**KIRKLEES METROPOLITAN COUNCIL  
INVESTMENT & REGENERATION SERVICE**

Reference No: **2025/NM/91324/E**

Site Address: Land adj, Inkerman Court, Barnsley Road, Denby Dale, Huddersfield, HD8 8XA

Description: Non material amendment to previous permission 2023/92871 for erection of 6 dwellings (modified proposal)

HOUSE TYPE U1 1903-HT-U1-01A
BARNSELEY ROAD, DENBY DALE
YORKSHIRE COUNTRY PROPERTIES
SCALE:1:100@A3 - FEB 2024

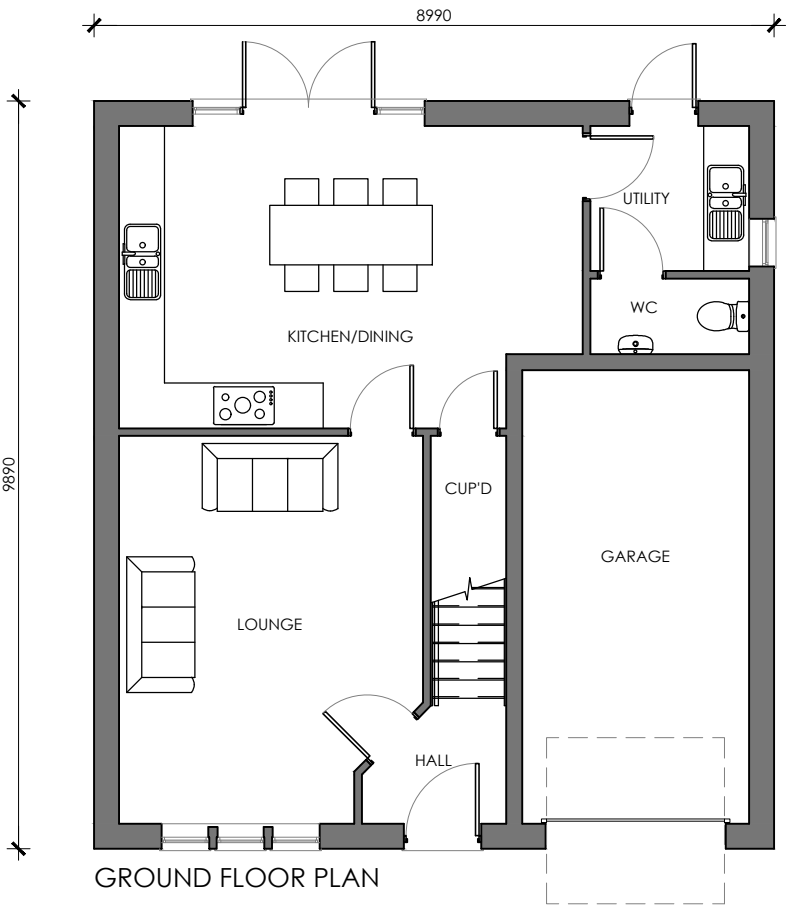
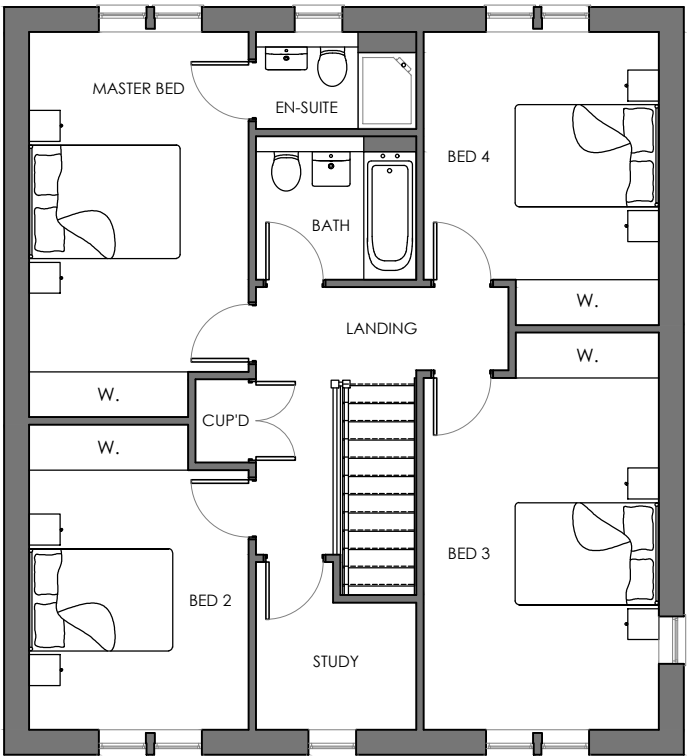
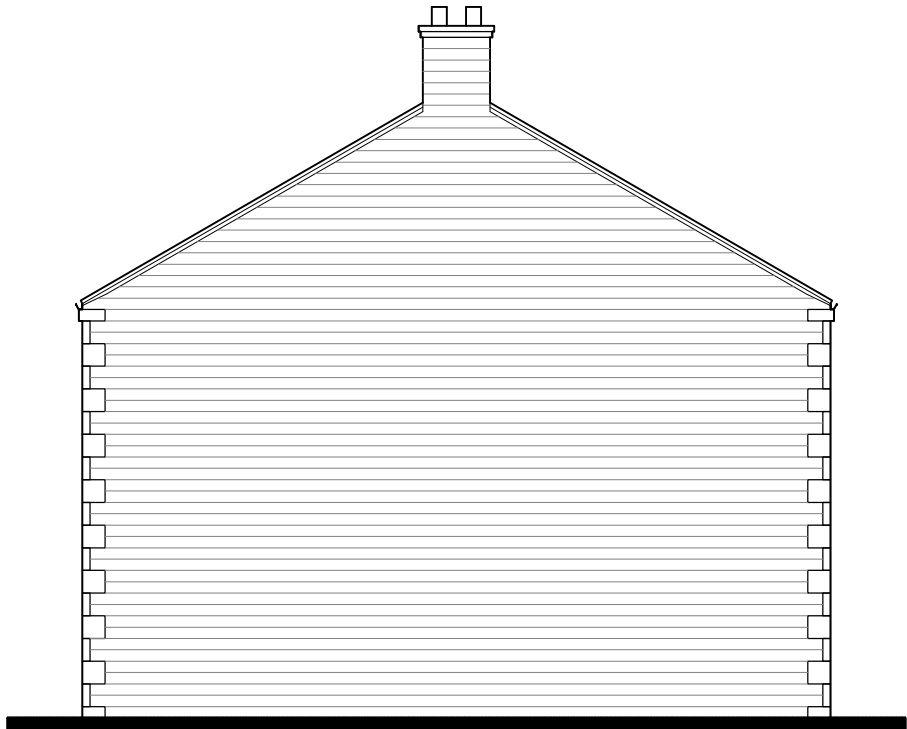
*U1 house type:*

- *Two windows added, to utility room and bedroom 3, on side elevation.*

The proposed amendments are illustrated in a drawing titled HOUSE TYPE U1 (drawing 1903-HT-U1-01A).

The proposed addition of two side windows (one to the ground floor utility room, the other to a first floor bedroom) at plots 29 and 30, being secondary windows to the respective rooms, is considered inconsequential. The new windows would face the gabled side elevations of the adjacent dwellings.

It is considered that the proposed amendments would not have a detrimental impact on visual amenity or living conditions, nor would they be detrimental to a third party.

I confirm that the changes may be considered as non-material amendments to the approved drawings. They are considered acceptable, and are hereby approved.
